NSW DEPARTMENT OF PLANNING AND INFRASTRUCTURE
PO Box 39
SYDNEY NSW 2001

**Subject: Mannering Colliery Modification 2 and Chain Valley Colliery
Modification 1**

Please find the following advice provided for proposed modifications to Mannering Colliery (MP06_0311) and Chain Valley Colliery (SSD-5465).

Proposed underground linkage
Chain Valley Colliery – Modification I
Figure 3.1

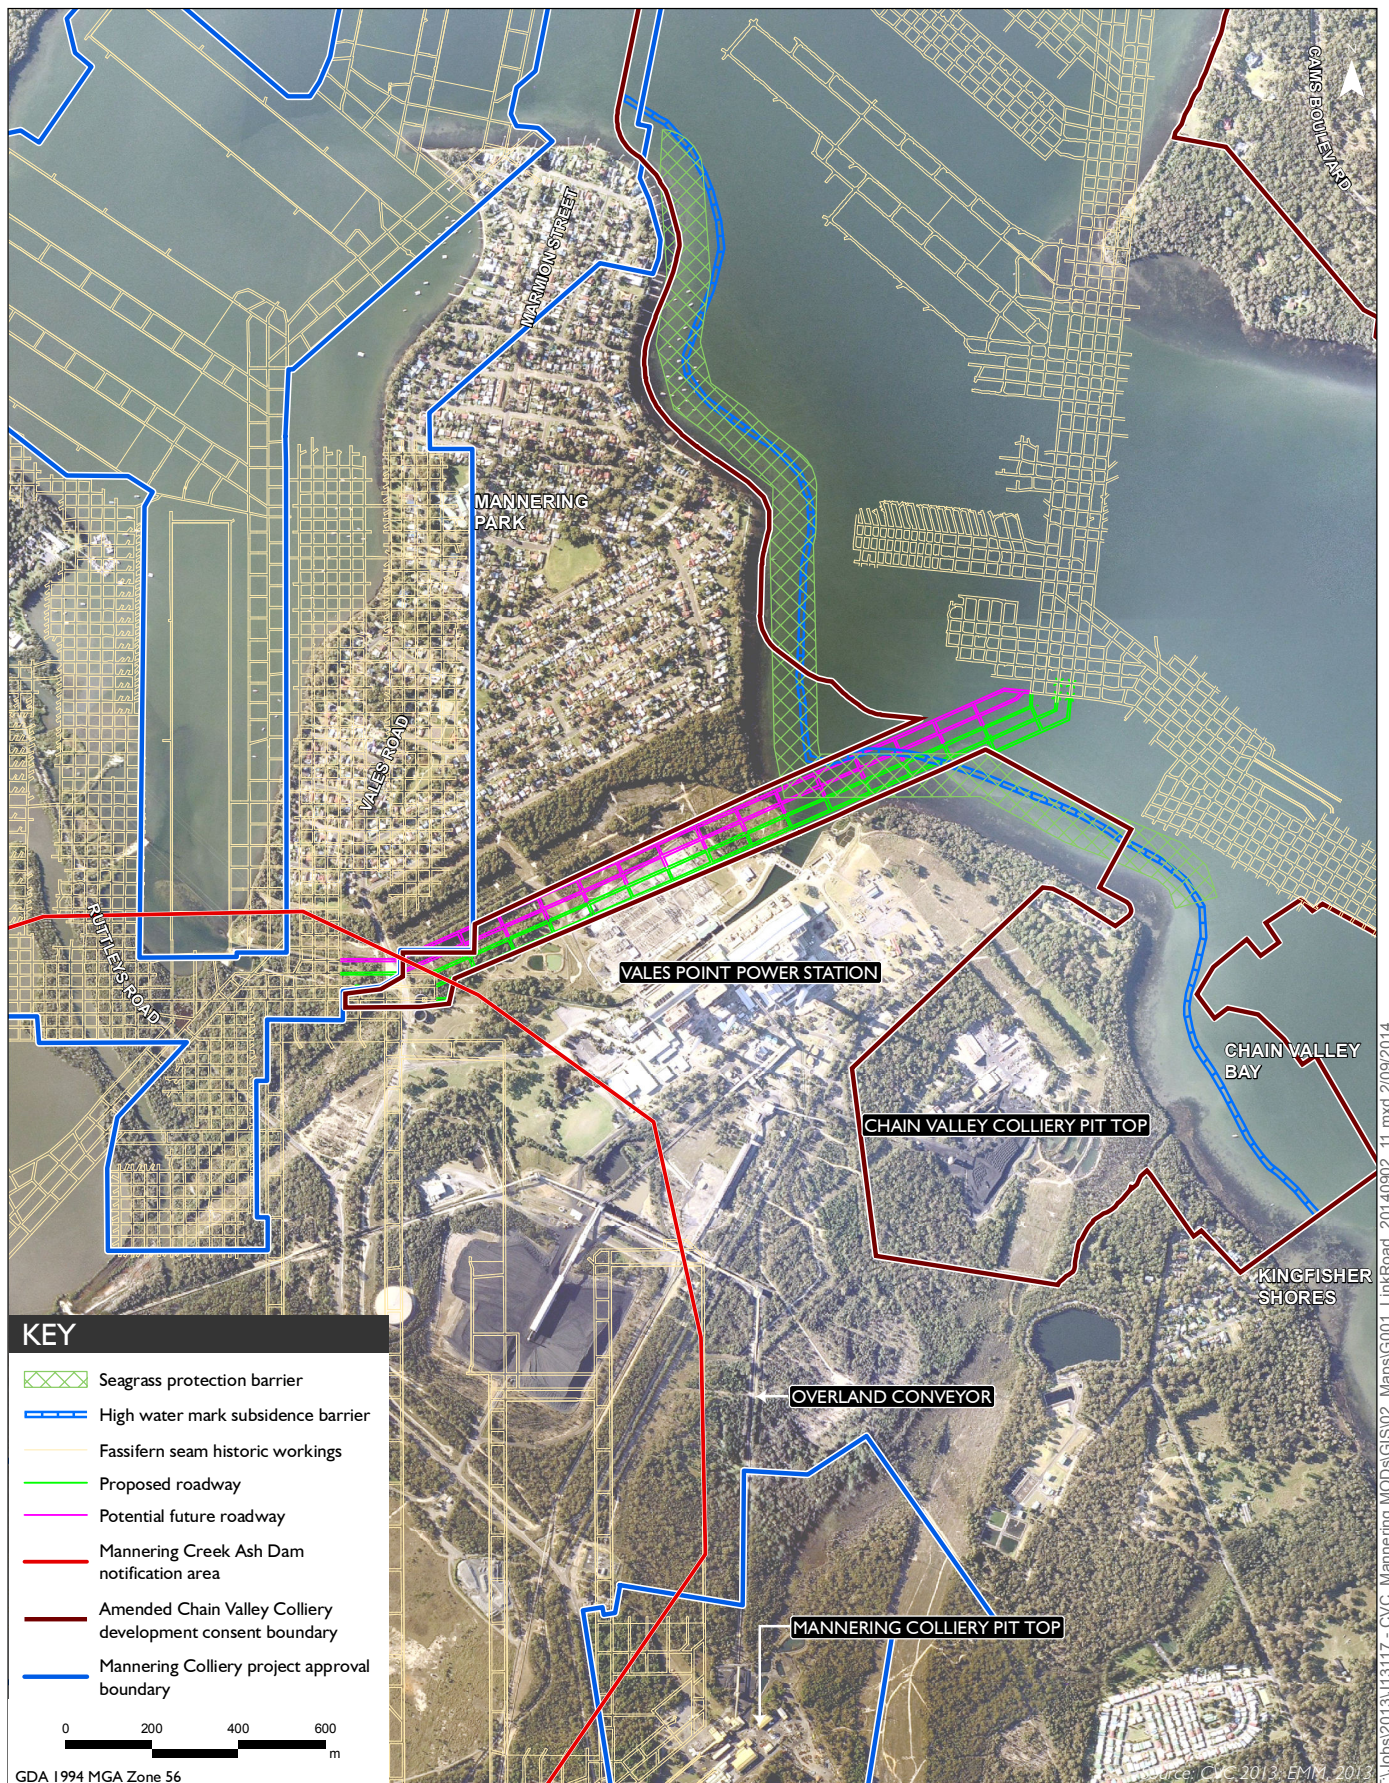
There is little or no discussion in the assessment provided of the need or justification for the additional northern roadways.

The effect of direct subsidence (Fig 5.2), and the cumulative effect of subsidence beneath previous workings (Fig 5.3) could be reduced by withholding approval for the additional northern roadways, particularly as the cumulative impacts are biased towards the northern side of the development as a result of the existing workings

FIGURE 4. Predicted Subsidence Isopachs Due to the Formation of the Connection Headings in the Fassifern Seam and Surface Features (Reproduced Figure 18b from DGS 2014)

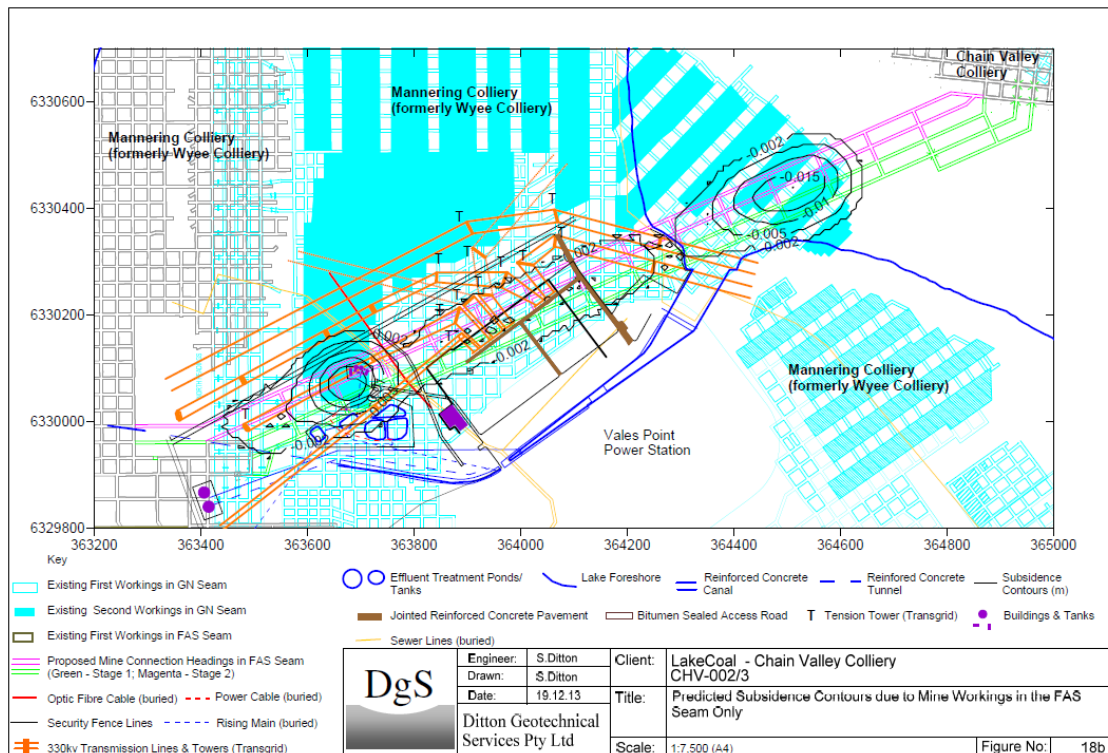
The footprint of the subsidence predicted as a direct result of the proposed roadway, as well as the cumulative effects of the proposed roadway and previous workings, show some impact on land <3m AHD in the vicinity of the lake foreshore and inlet canal. The maximum predicted effect of subsidence is 20mm, but even this small change can alter the distribution foreshore plant of species sensitive to tidal inundation and groundwater such as mangroves, salt marsh and swamp mahogany.

It is desirable to reduce subsidence in the vicinity of the lake foreshore as much as possible.
